Our Ref: BE/137/19/RES

Application for Approval of Reserved Matters Following Outline Approval

Development Application for approval of phase 2 reserved matters following outline permission
BE/63/17/OUT (as amended by BE/131/18/PL) for 20 No. dwellings.

Location The Cottage Shripney Road Bognor Regis

A Plot 7 Elevation
SCALE 1:100 @ A3

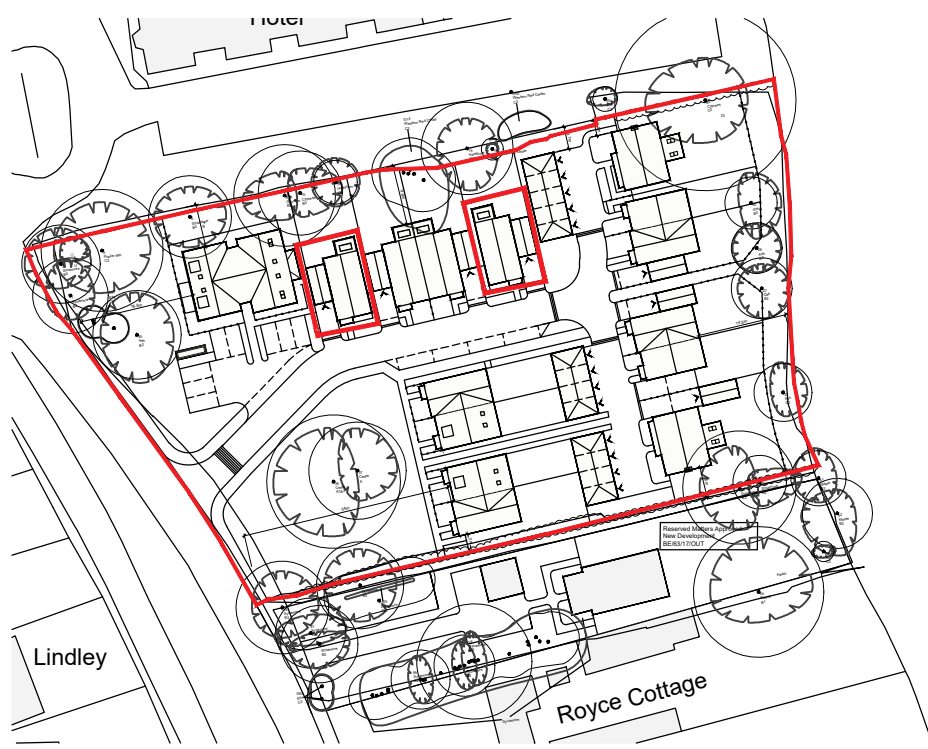
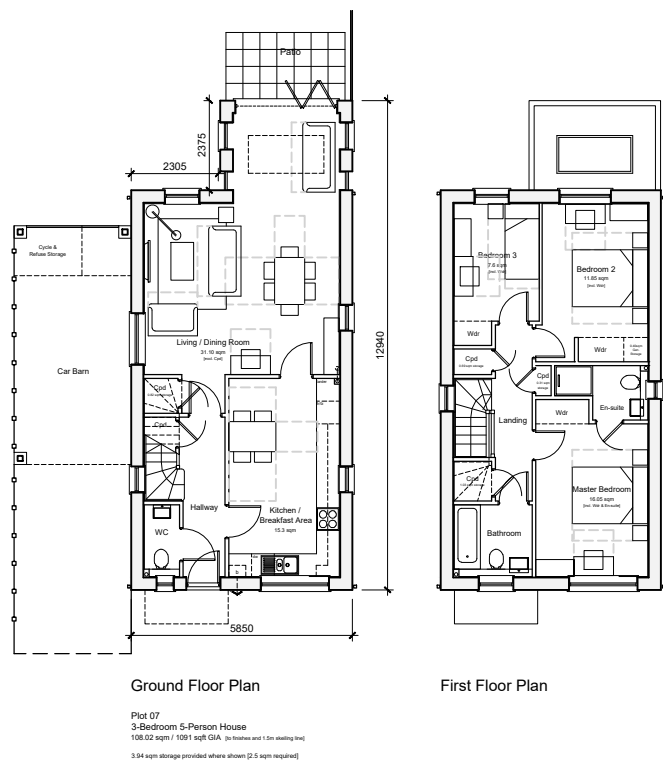
Plots 14 & 15 elevations are labelled incorrectly. Please amend accordingly.

Plots 12 & 13 elevations are labelled incorrectly. Please amend accordingly.

Plots 13 & 14 elevations are labelled incorrectly. Please amend accordingly.

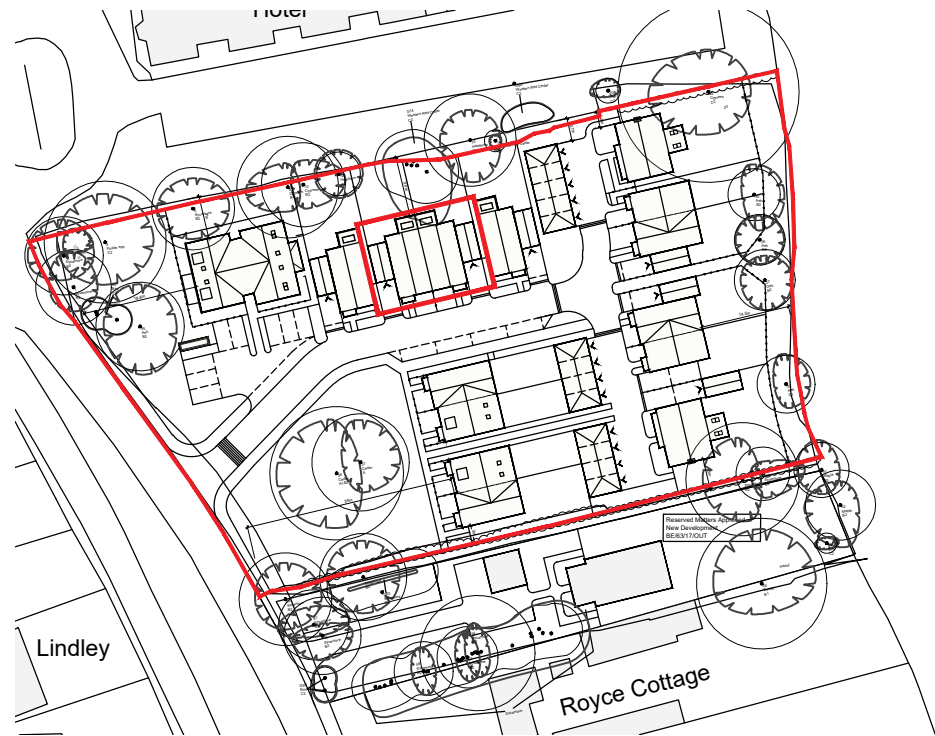
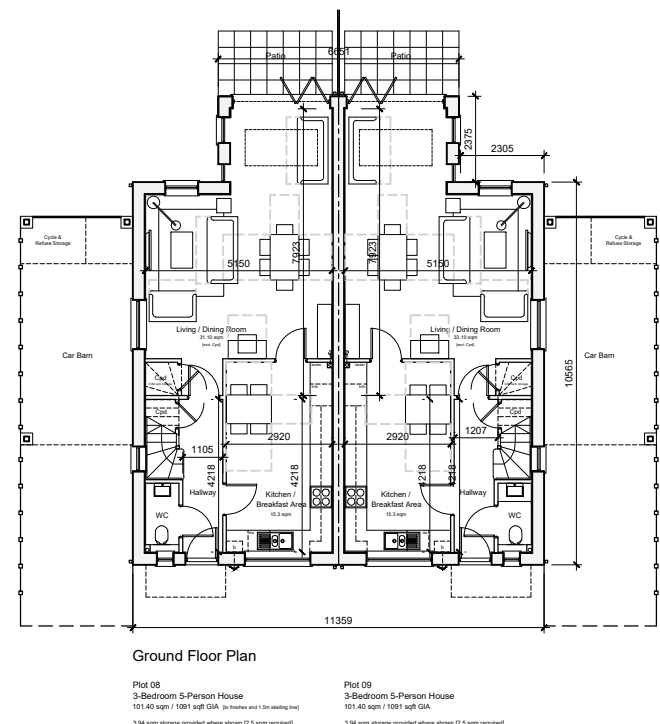
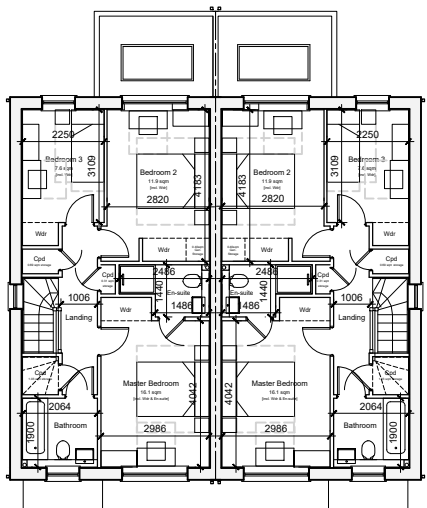
Plots 7 & 10 please show the car barns on the floor plans.
